**KIRKLEES METROPOLITAN COUNCIL
INVESTMENT & REGENERATION SERVICE**

DELEGATED DECISION TO DETERMINE PLANNING APPLICATIONS

Reference No:	2021/62/93622/W
Site Address:	Concept Refridgeration Ltd Midway House, 51, Huddersfield Road, Meltham, Holmfirth, HD9 4AF
Description:	Partial demolition, change of use and alterations to form dwelling (Adj Listed Building Within a Conservation Area)
Recommending Officer:	Stuart Howden

DECISION – Conditional Full Permission

SOUTH ELEVATION

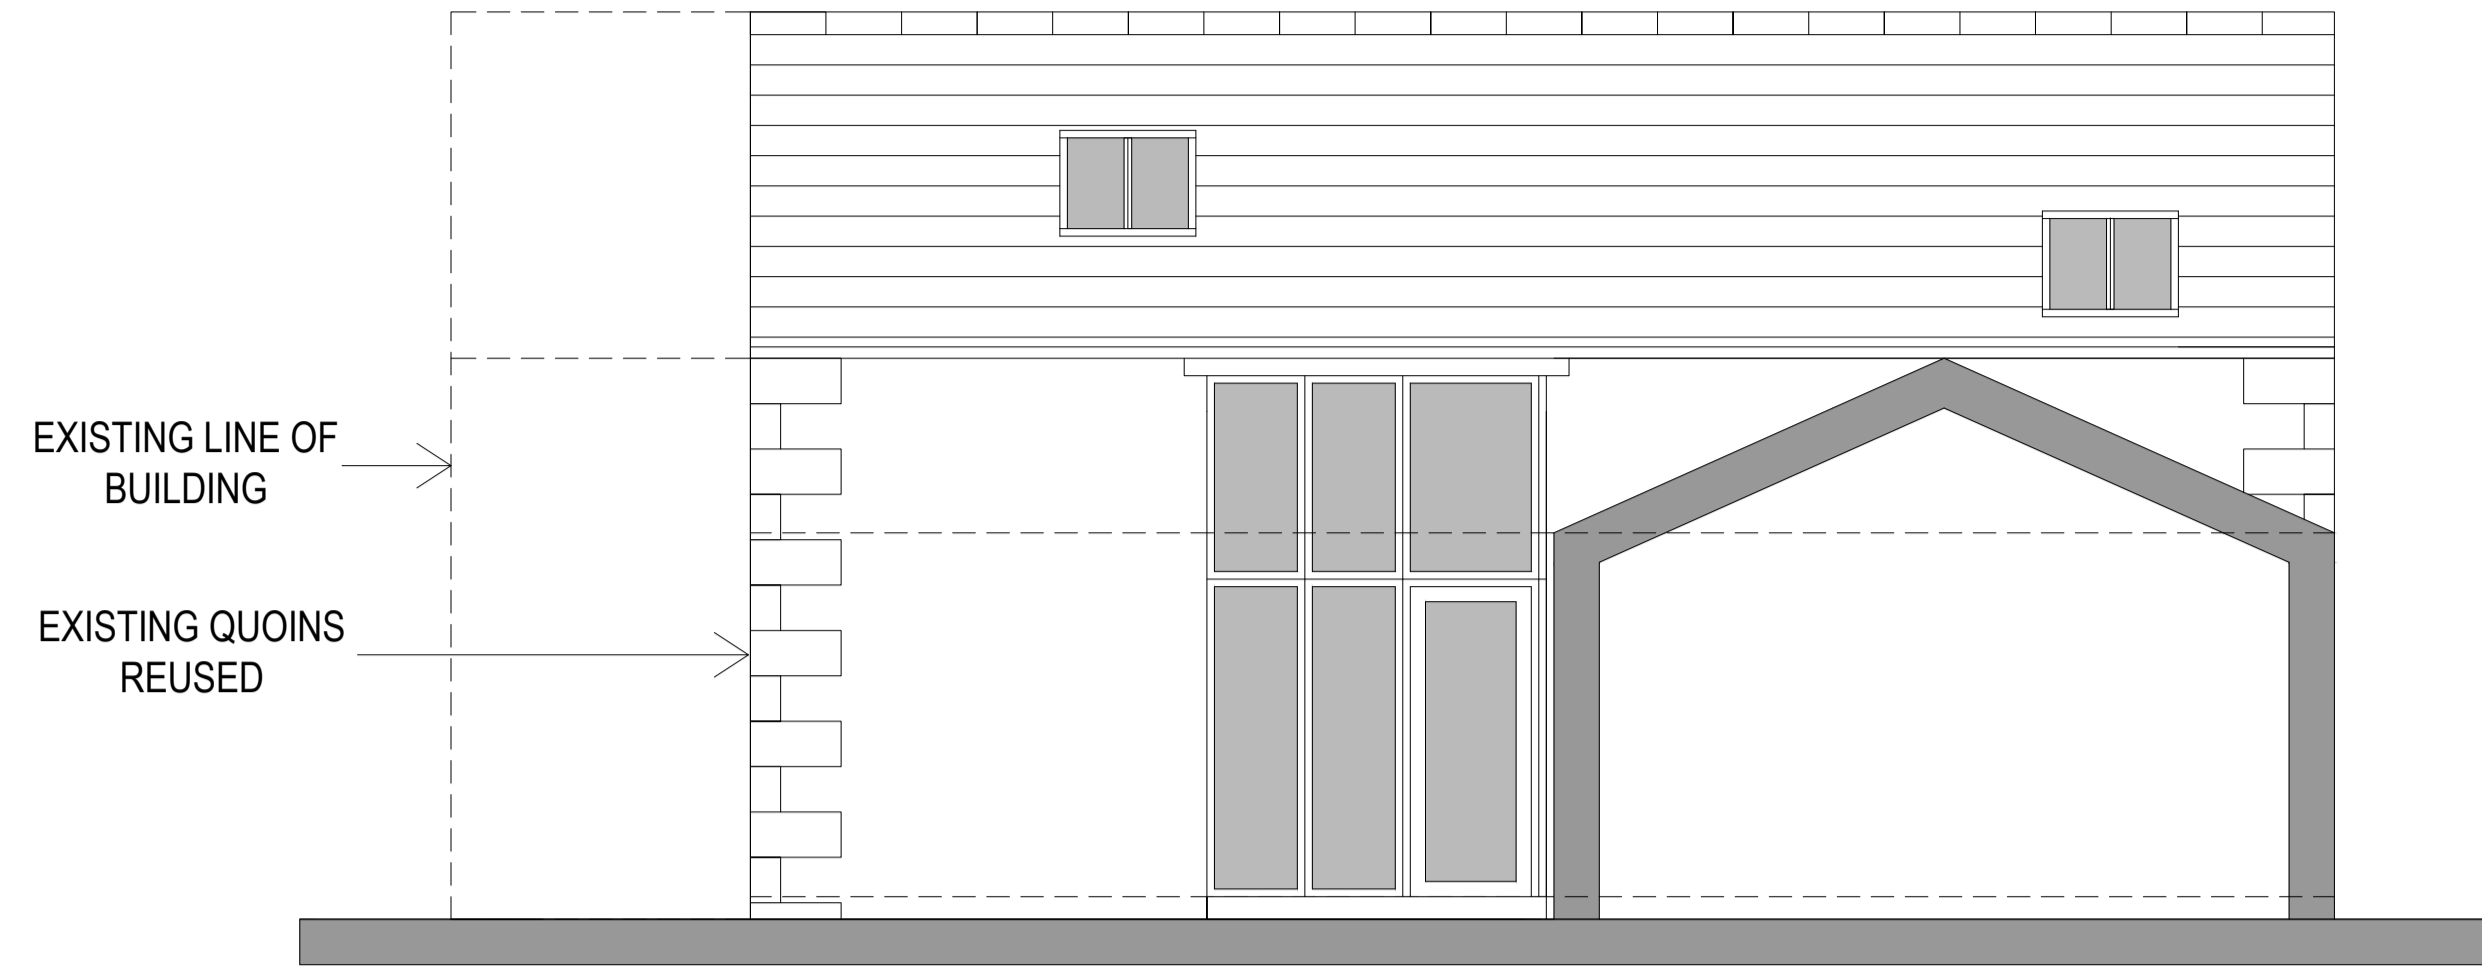
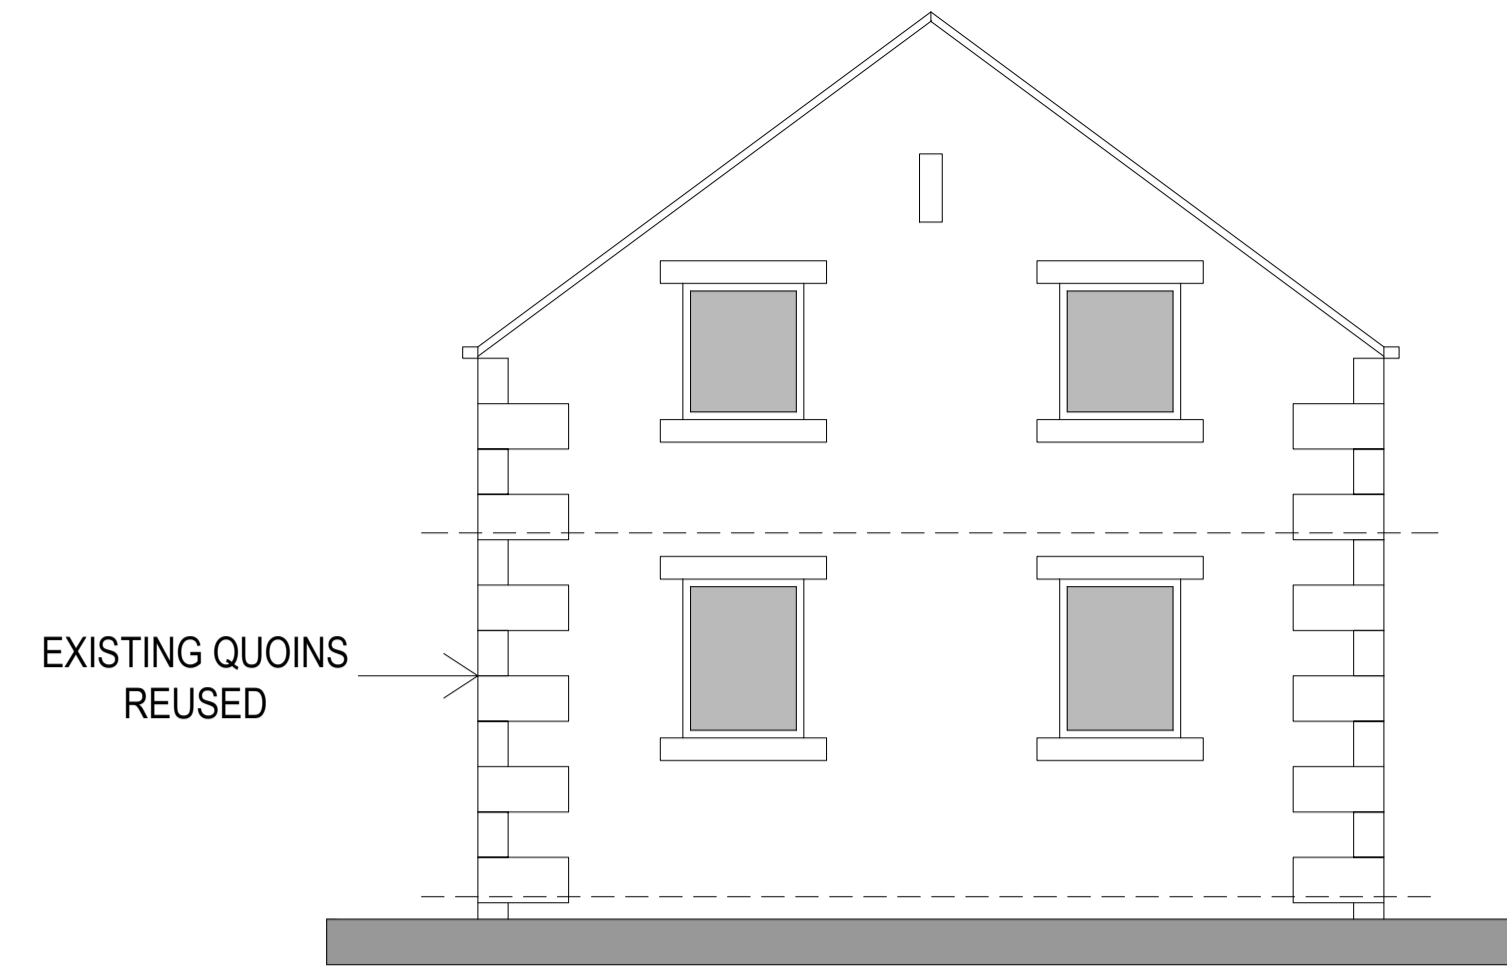
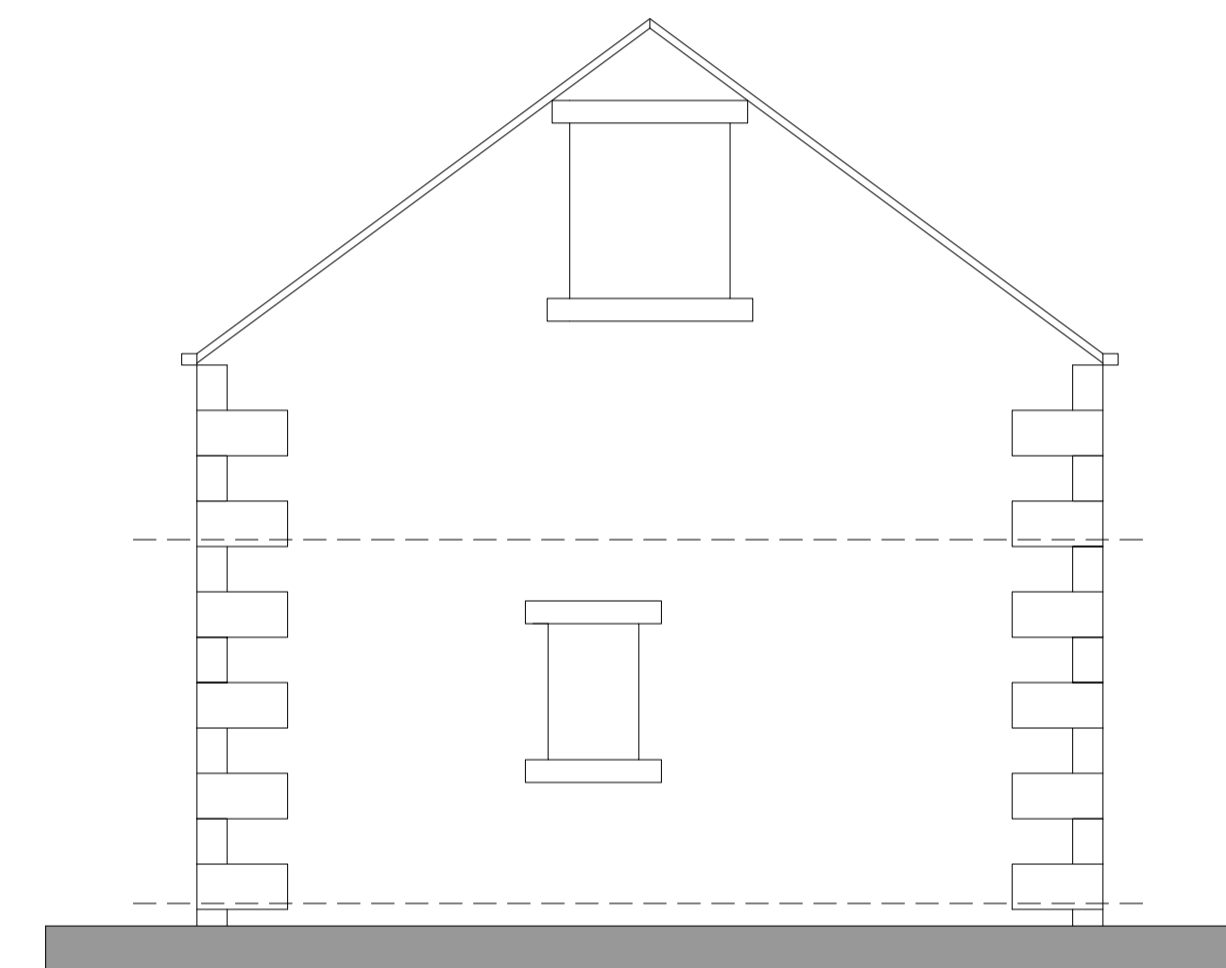
The Conservation Officer states that although the historic roof covering is likely to have been stone slates, the proposed use of natural blue slates is an acceptable alternative as this would be an enhancement to the existing corrugated sheet roofing and will introduce a traditional material which is commonly used in the town. Officers concur with the Conservation Officer in relation to the materials to be used for the roof, but a sample of the finished material will be requested to ensure a high-quality finish

In terms of the rooflights, these are considered acceptable in principle and do not appear cluttered on the roof slope. However, these should be conservation style roof lights.

For completeness and to ensure a high-quality finish, full details of all window frames, doors and rooflights are to be conditioned.

WEST ELEVATION

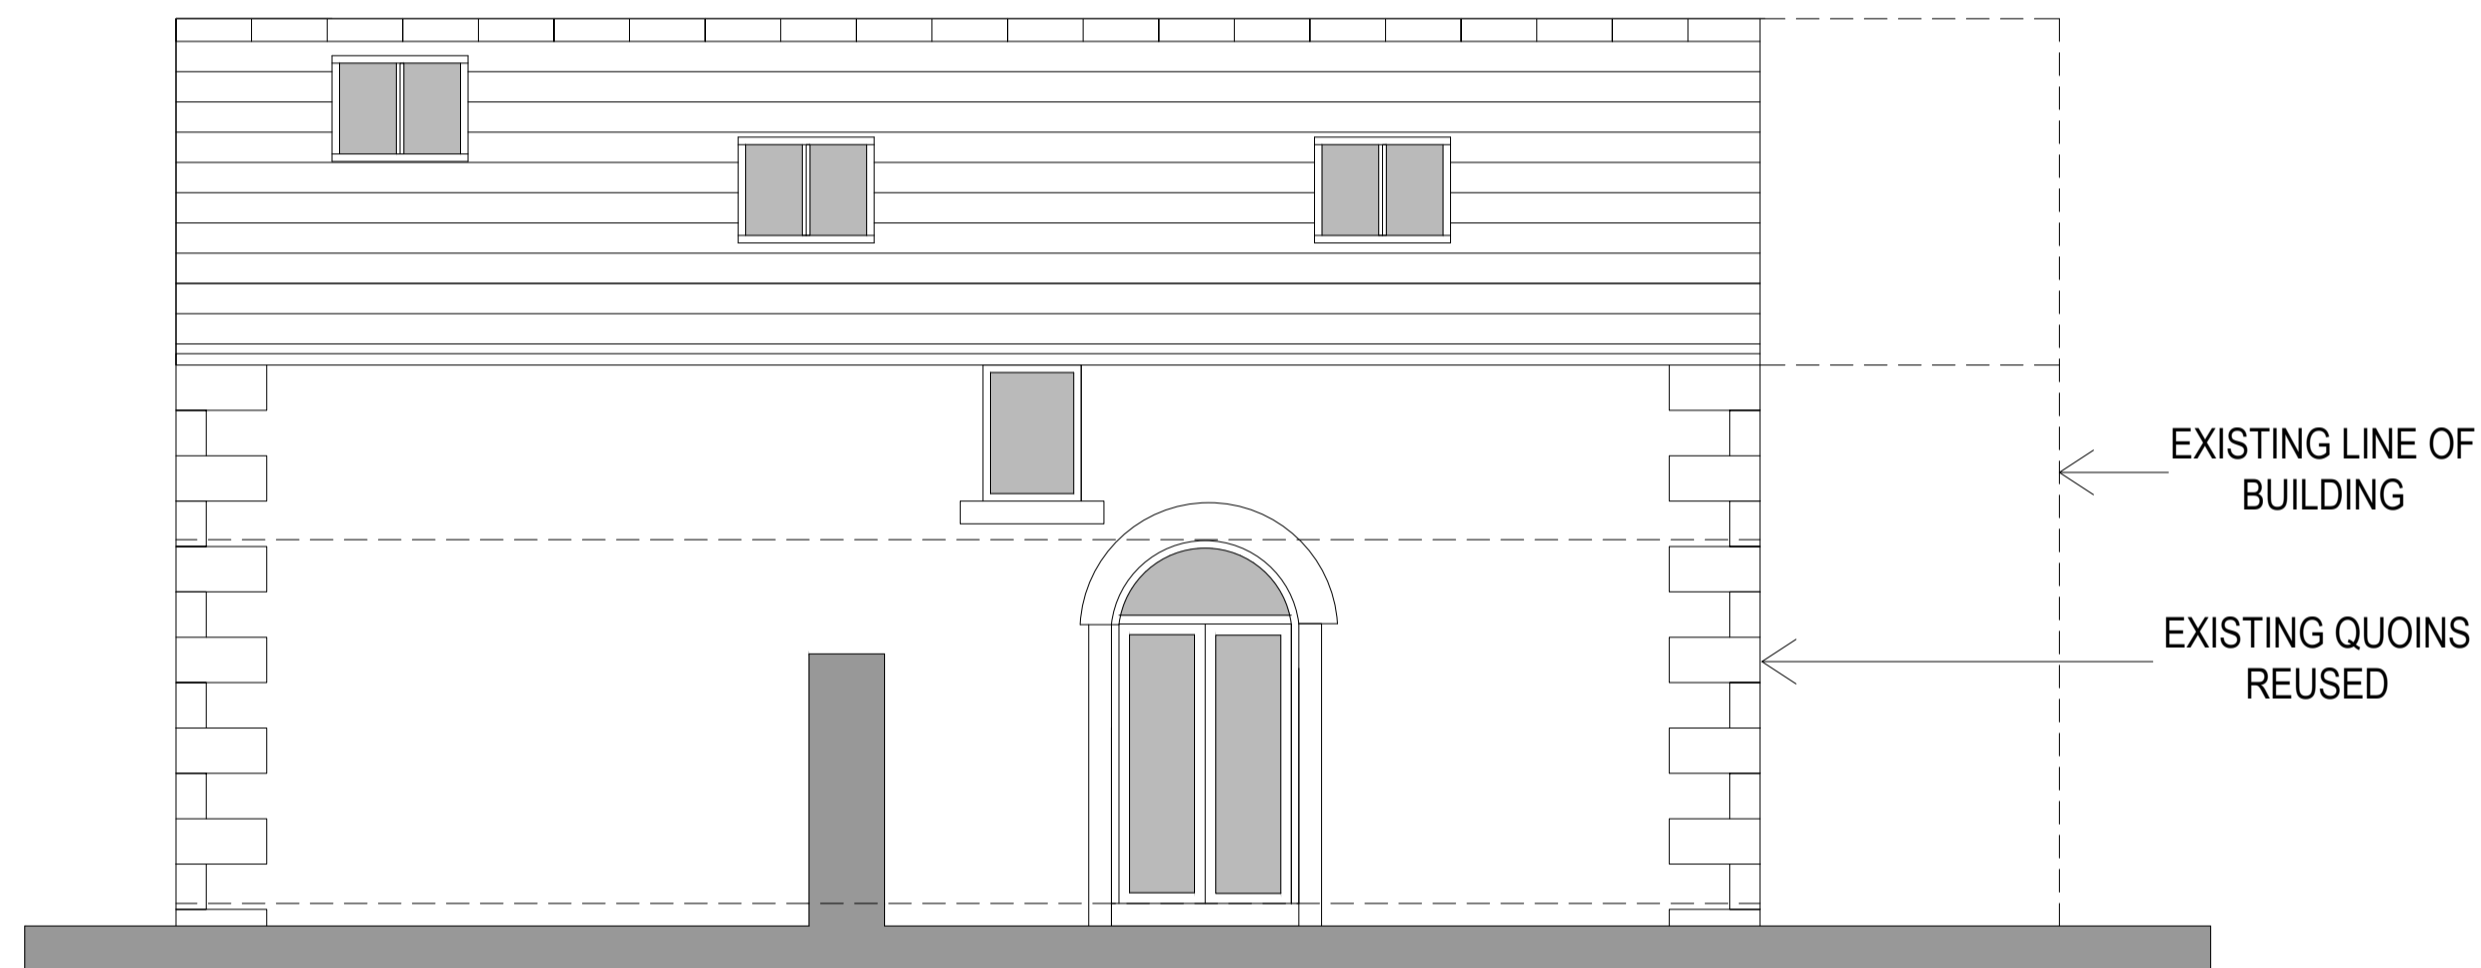
The proposal would replace two openings, one being a large barn replaced with a glazed element and a doorway being used glazed doorway. The use and retention of these historic openings is welcomed as these are considered to be an important contribution to the character of the building. That being said, the glazing of the doorway is somewhat domestic in appearance. The new first floor window on the north elevation is considered acceptable in principle and would not overly domesticate this elevation. The four windows in the west gable elevation are considered unfortunate and the quantity of windows here along with the engineered appearance in terms of siting give this elevation a domestic appearance somewhat eroding the character of the building.

Thus, Officers consider that the proposal would cause less than substantial (albeit minor) harm to the Meltham Conservation Area given the quantity and siting of glazing of the west gable, which would somewhat erode the character
